From: Nicola Spencer
Sent: 01 June 2026 10:36
To: william maynard
Subject: RE: Planning application LU/120/26/HH 7 Norfolk Place Littlehampton
Attachments: Extracted pages from PACK 1.pdf

Thank you for your recent planning application. Unfortunately, there are a number of issues that need to be resolved:

Existing North Elevation

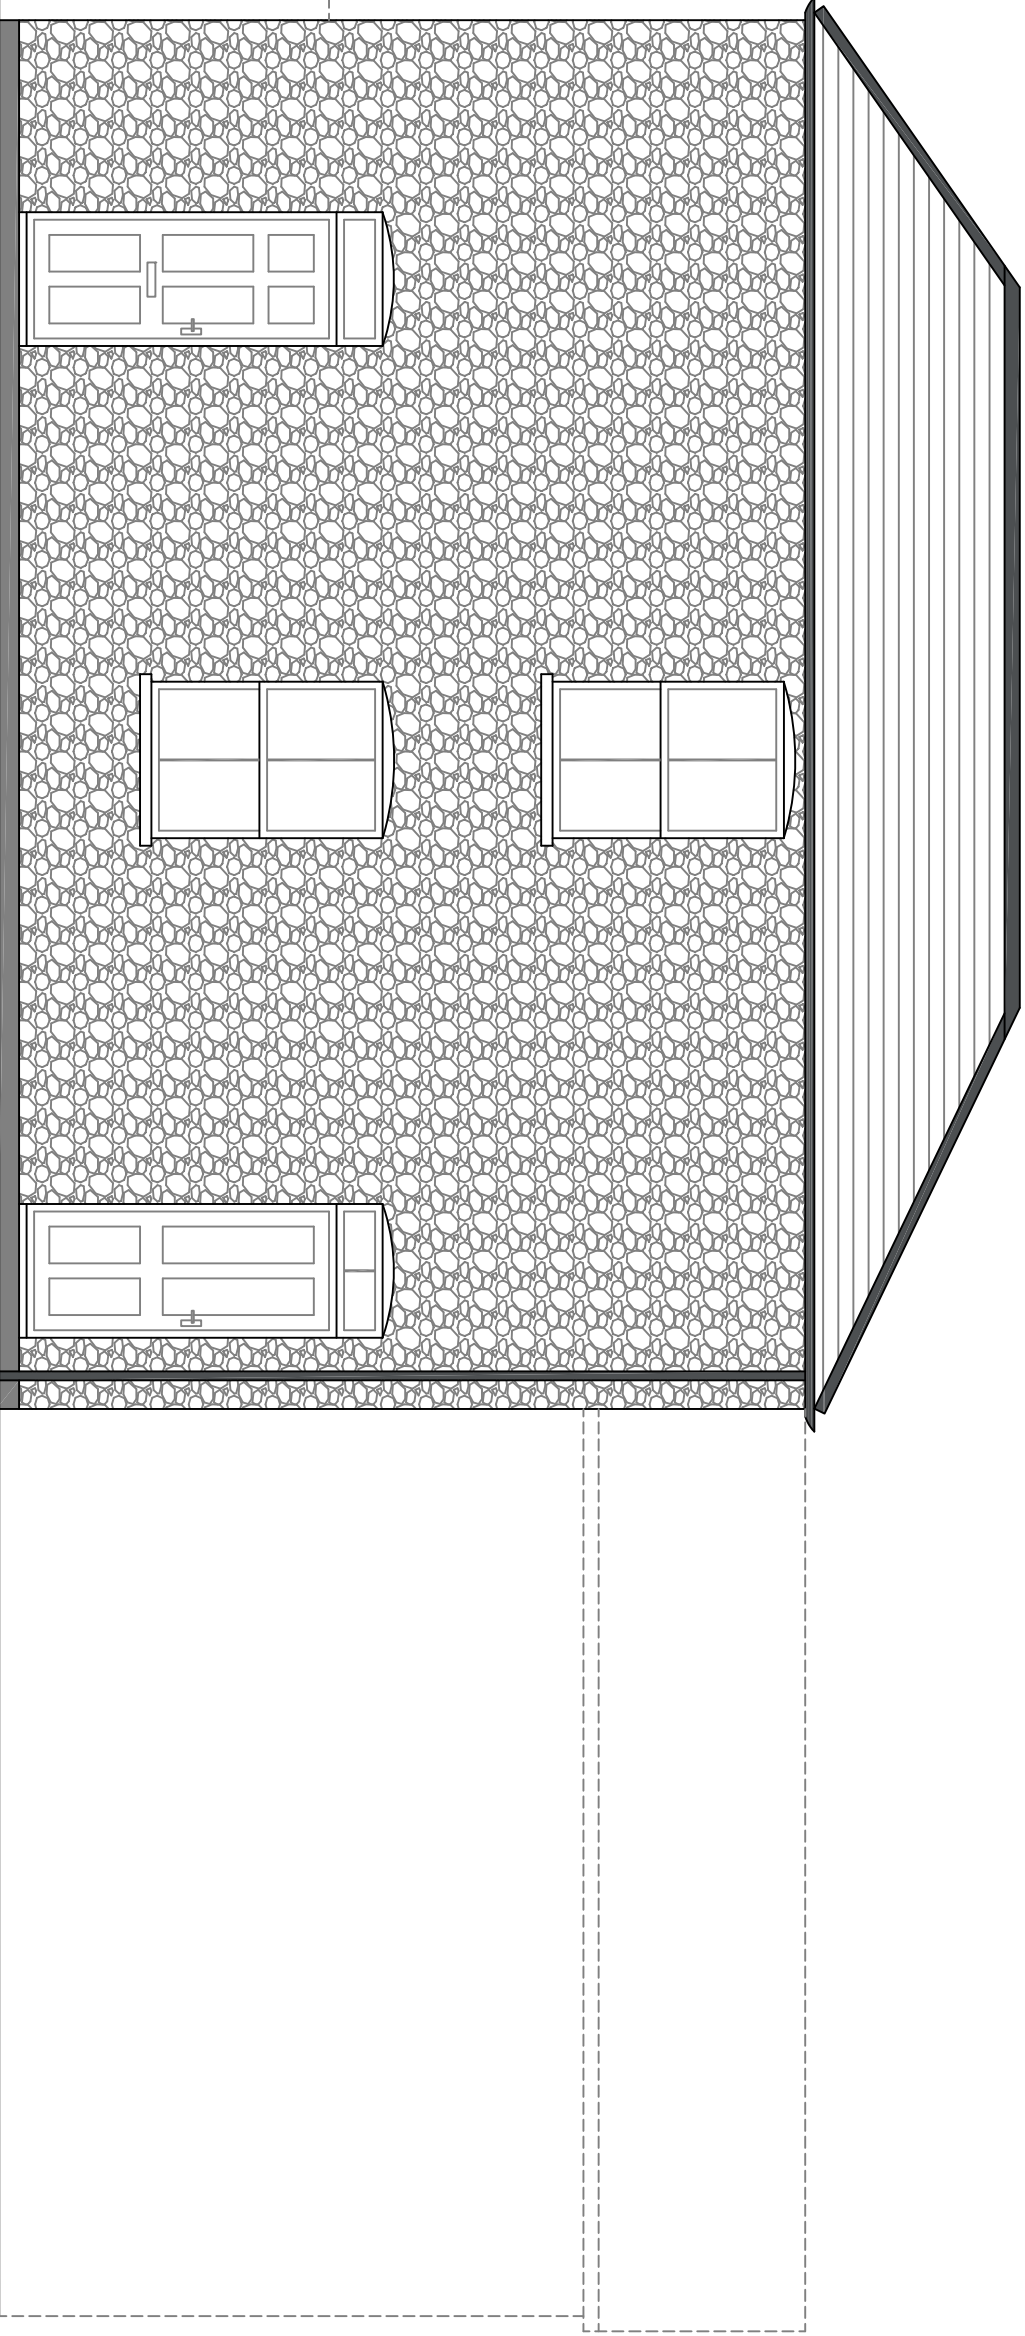
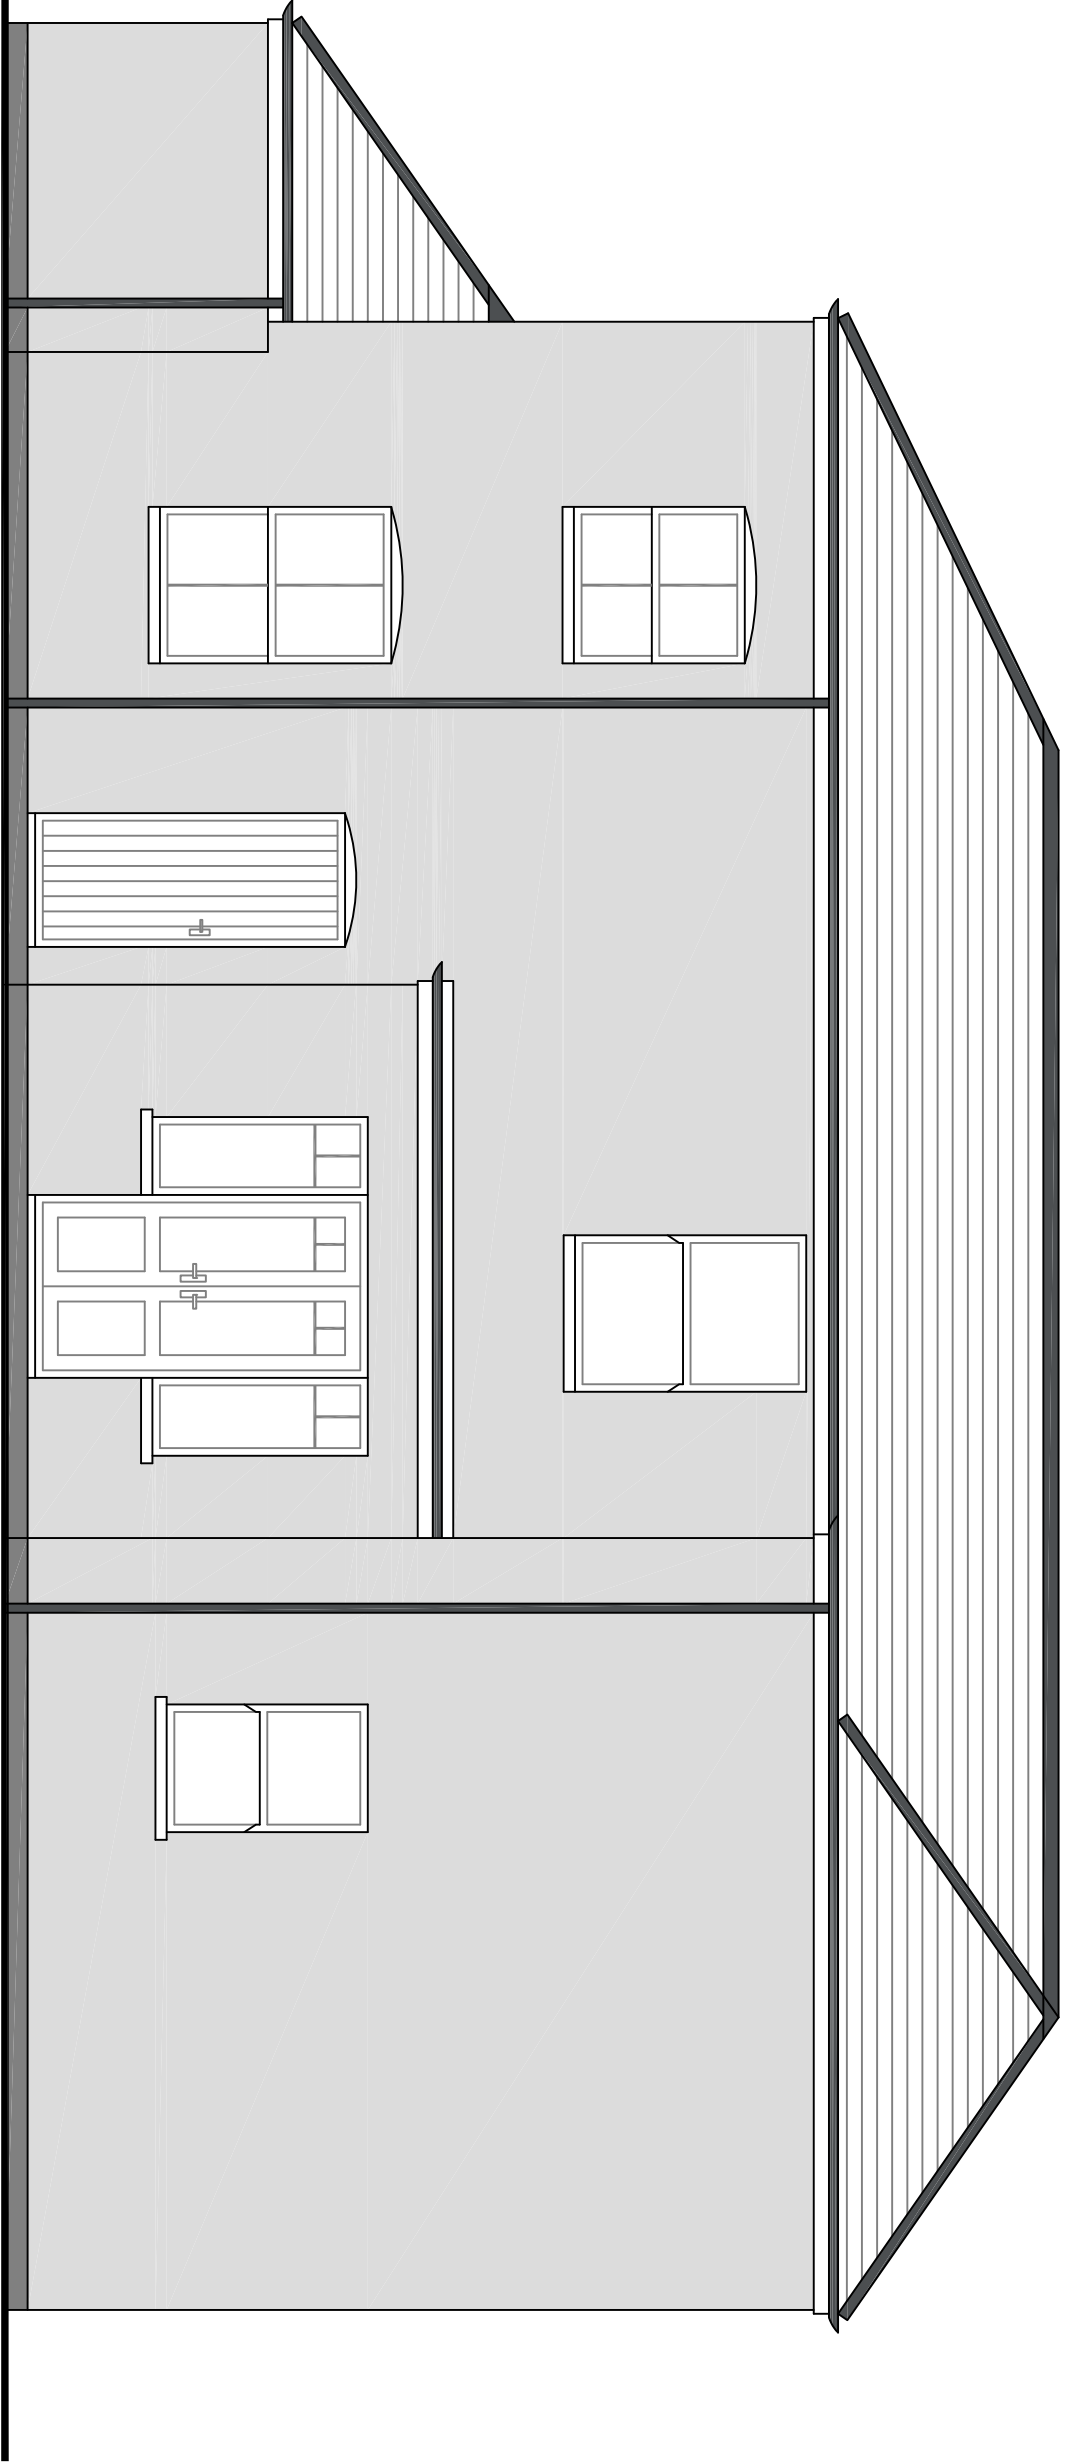
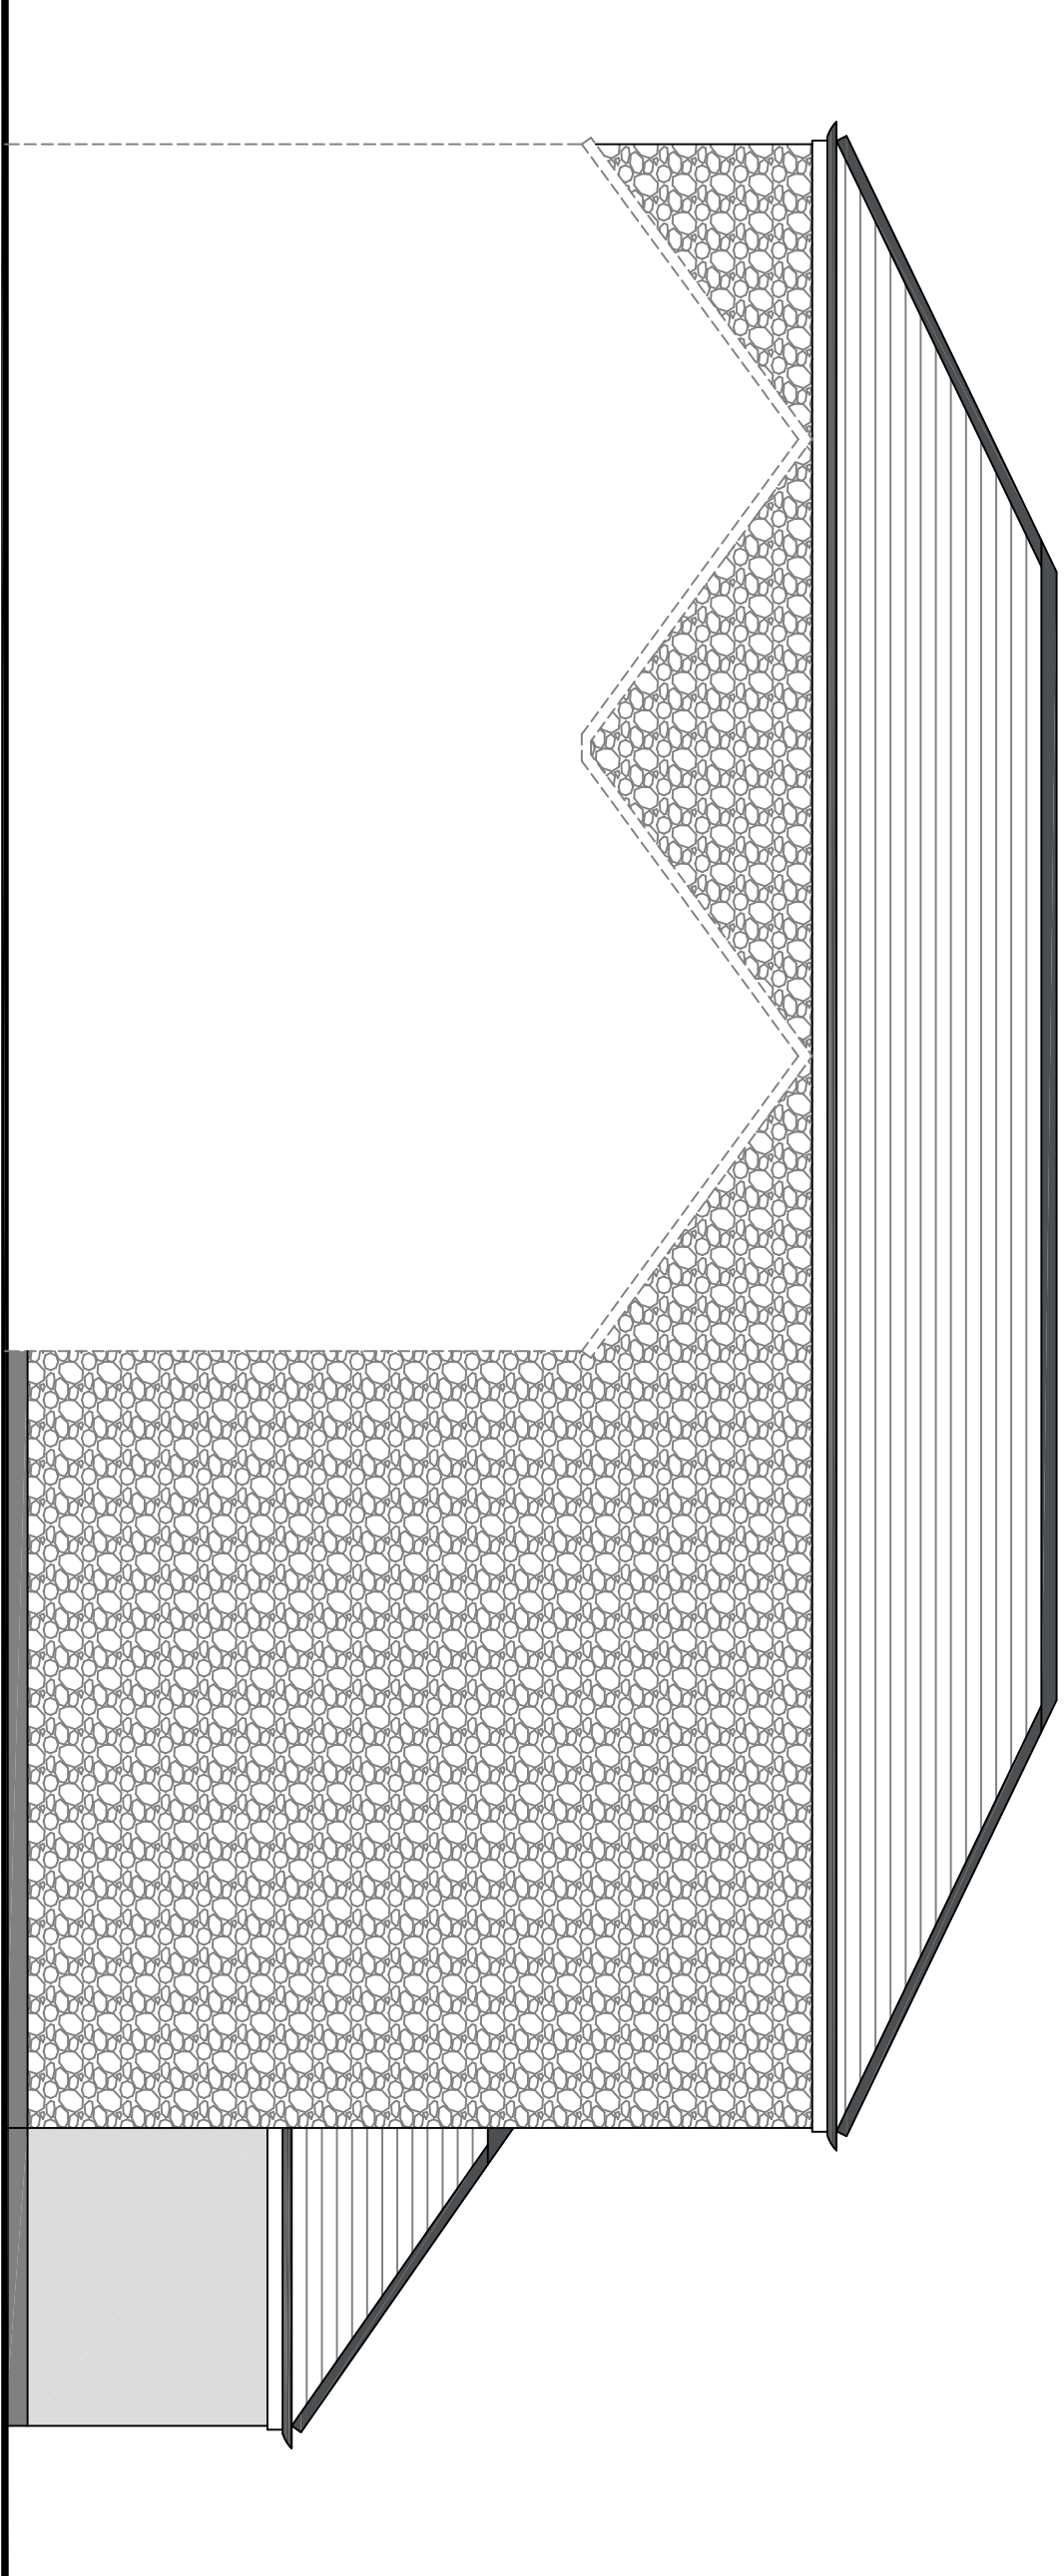
4. Block plan – a plan at the scale of 1:500 clearly indicating where the works have been carried out e.g. hatching the roof that has been replaced.
5. Elevations – please provide elevation plans at a scale of 1:50 or 1:100. Whilst your photographs are helpful, we need to be able to scale from the elevations. One set of plans will be acceptable if clearly labelled pre-existing and existing as the works have already been carried out.
